Office of Environment & Heritage

DOC16/549616-1
SSD 6300

Rixs Creek Coal Mine Extension Project - Response to Submissions Report

ATTACHMENT 1: OEH REVIEW OF THE RIXS CREEK RESPONSE TO SUBMISSIONS REPORT

Figure A : Original Approval : Final Landform Areas (Fixed Infrastructure Excluded)

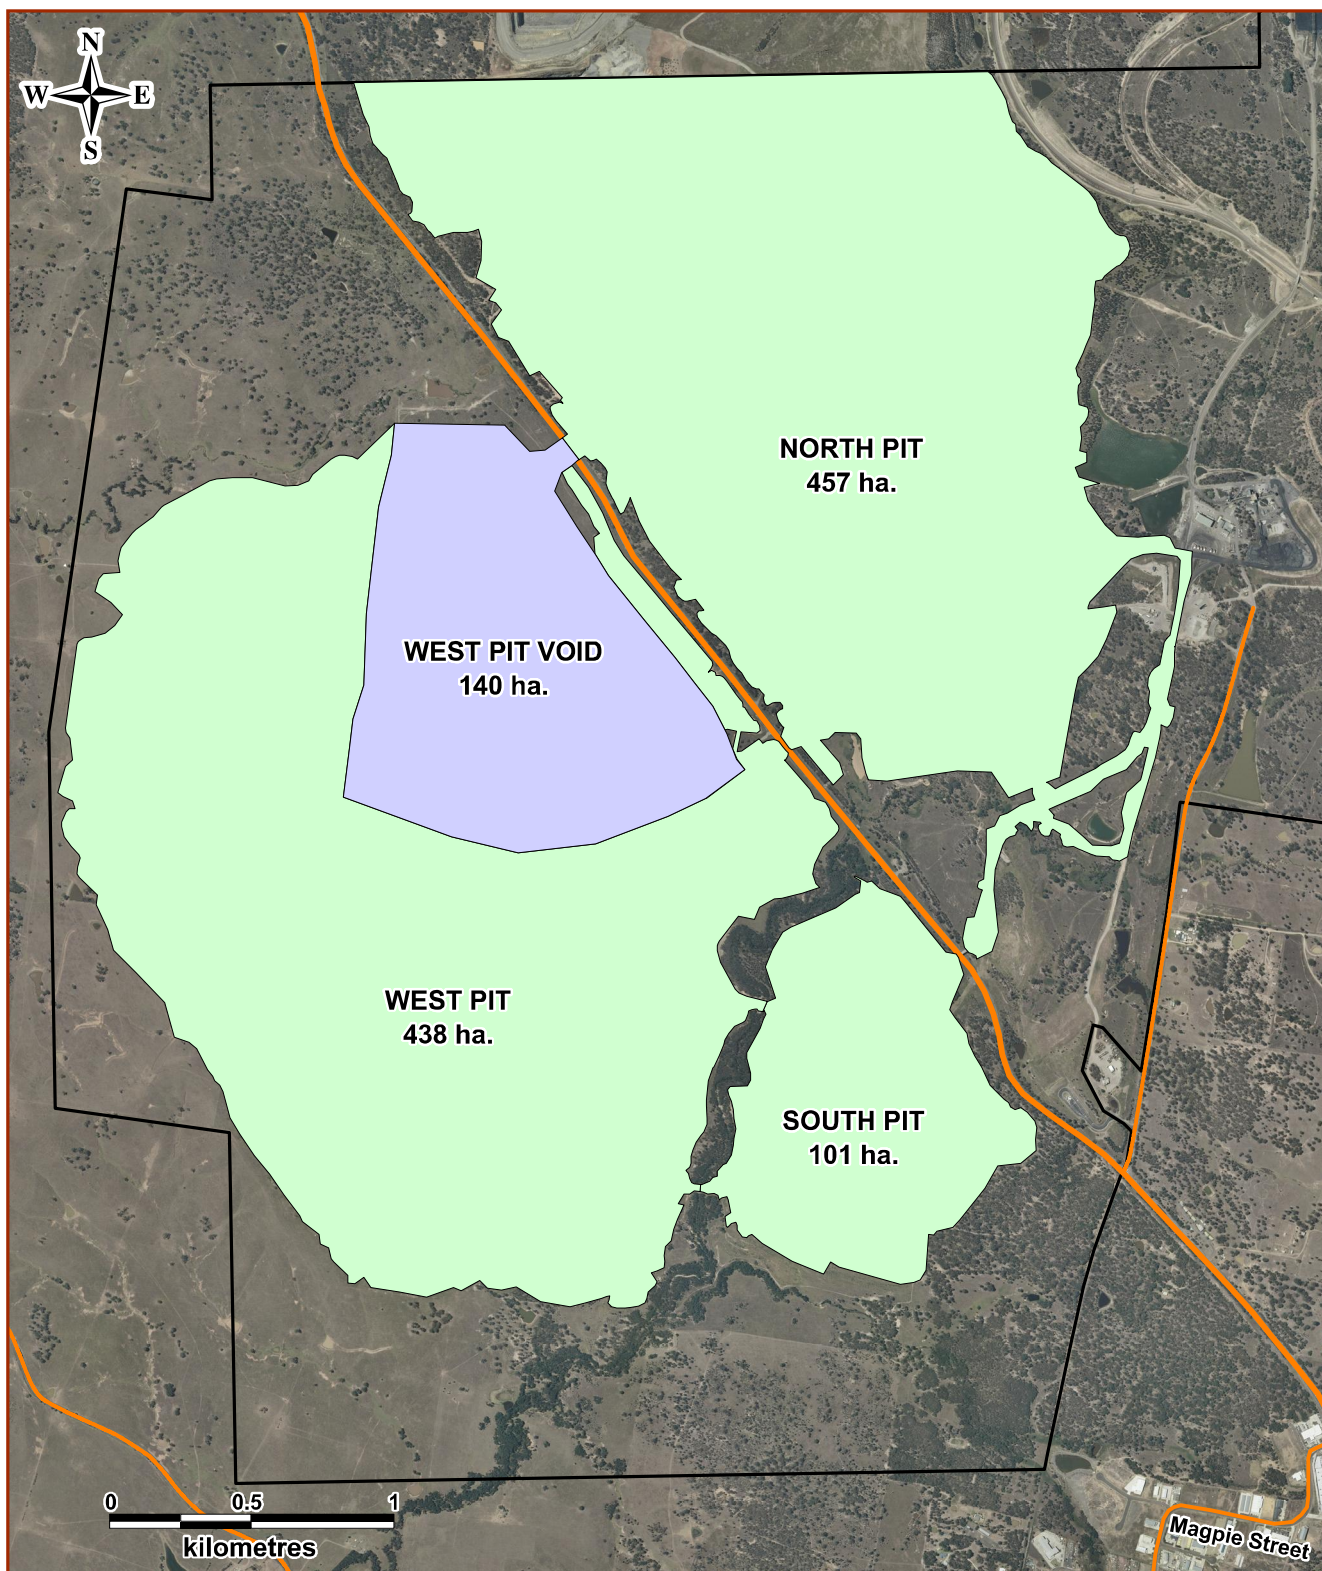
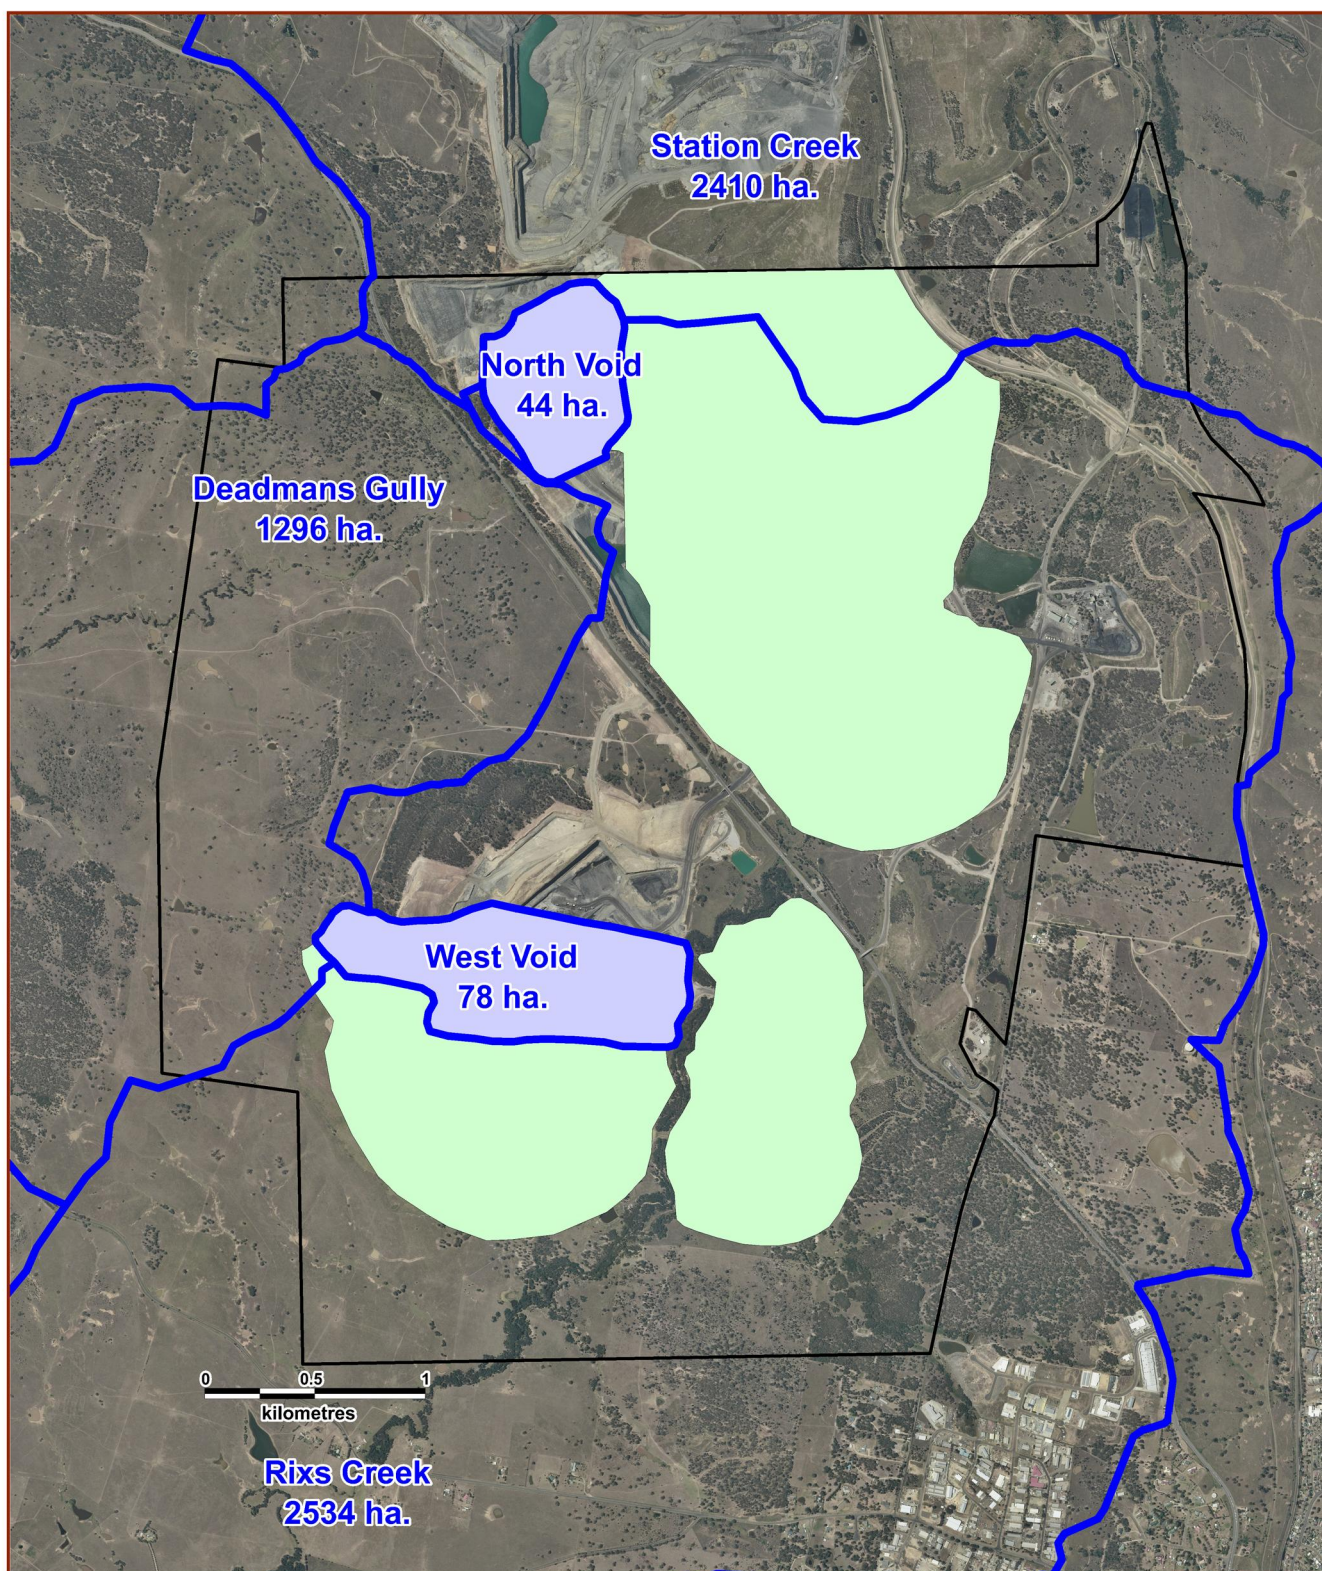
OEH notes that the size of the catchment areas in the Rixs Creek coal mine area have been decreased, apart from the catchment to Station Creek. However, the flood affected land along Station Creek is all mine-owned land. Flood modelling has shown that some mine assets are likely to be impacted by flooding and therefore that flood protection works will be required. Since the flood risk will not affect other privately owned land OEH has no further comment on this aspect of the project.
